WEST SUSSEX COUNTY COUNCIL CONSULTATION

TO:	Arun District Council FAO:Raymond Cole
FROM:	WSSC - Highways Authority
DATE:	10 July 2020
LOCATION:	Land north of Hook Lane Pagham Bognor Regis
SUBJECT:	P/57/20/DOC Approval of details reserved by condition imposed under ref P/30/19/OUT relating to Condition No 6 - design code masterplan.
DATE OF SITE VISIT:	n/a
RECOMMENDATION:	Advice
S106 CONTRIBUTION TOTAL:	n/a

Street Sections

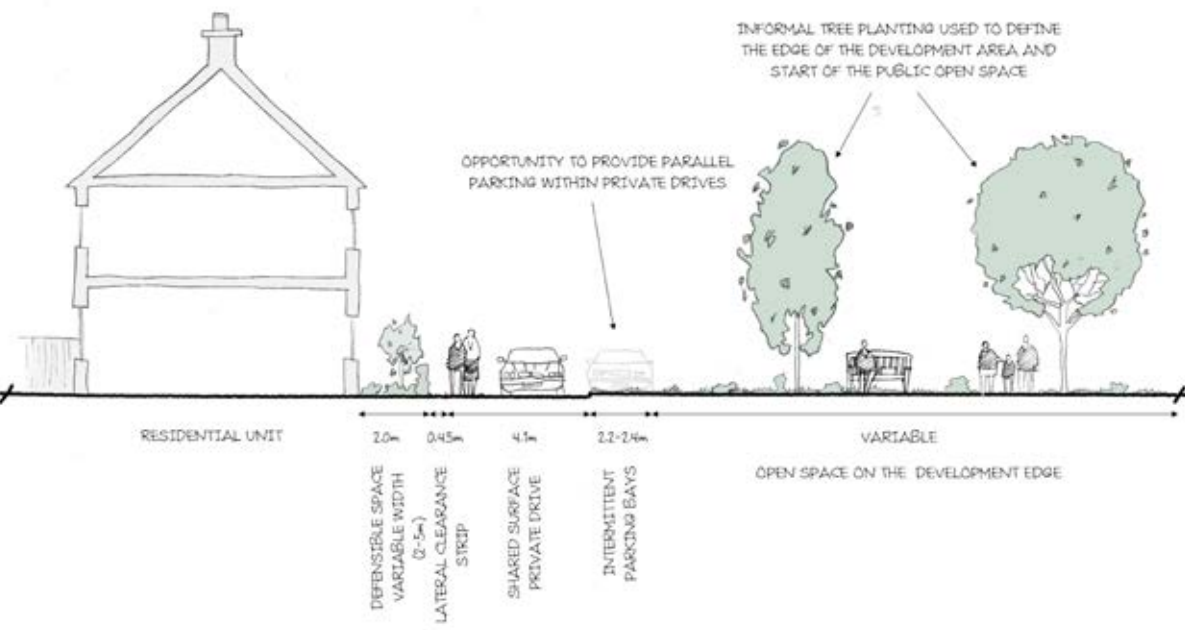
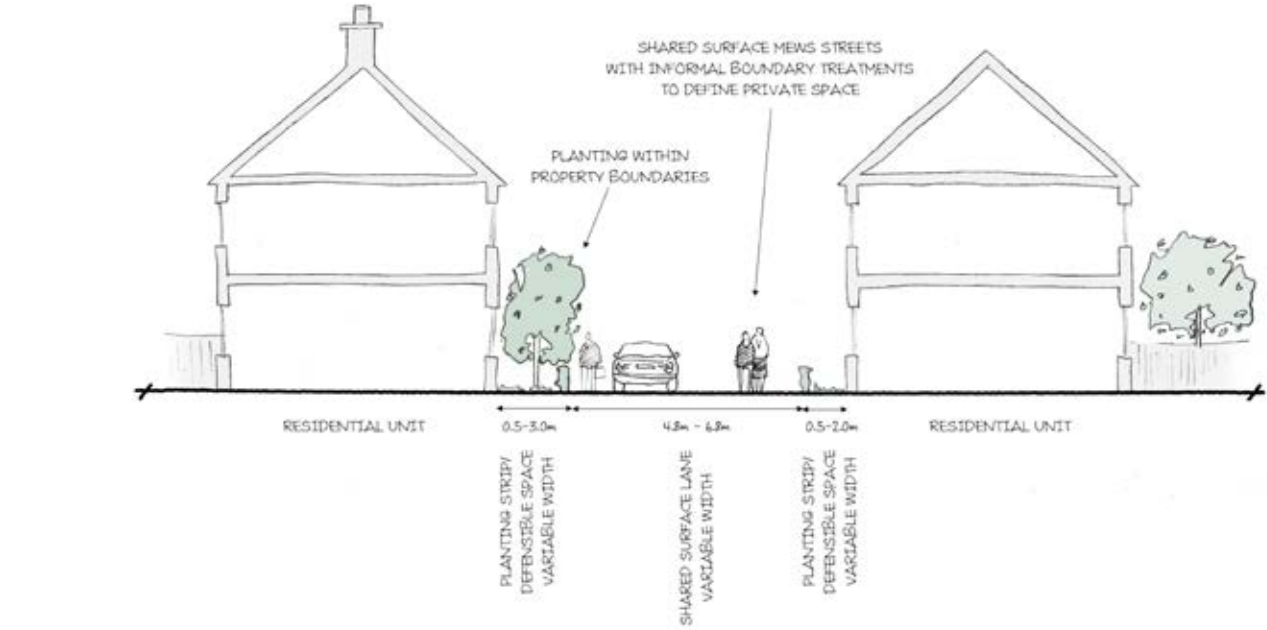
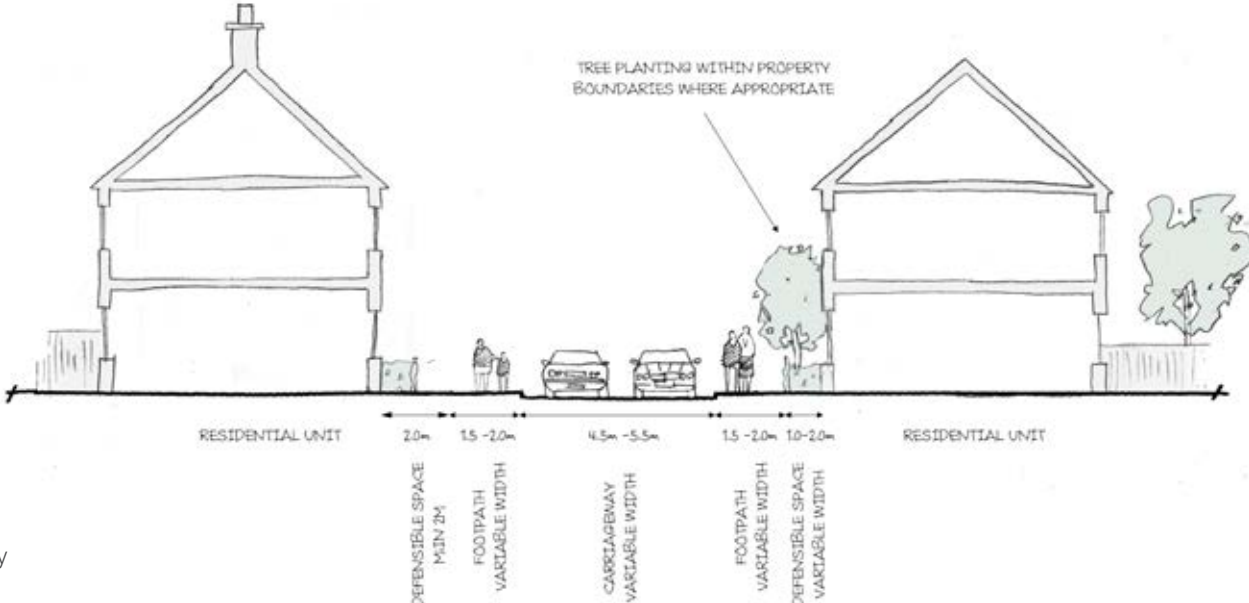
Shared Surfaces – Where shared surfaces are provided, a service margin would be required. This would be required to accommodate services and enable maintenance of the carriageway edge. The width of the margin should be adequate to accommodate the services within it but must be no less than 500mm wide. The typical sections should allow for a service margin.
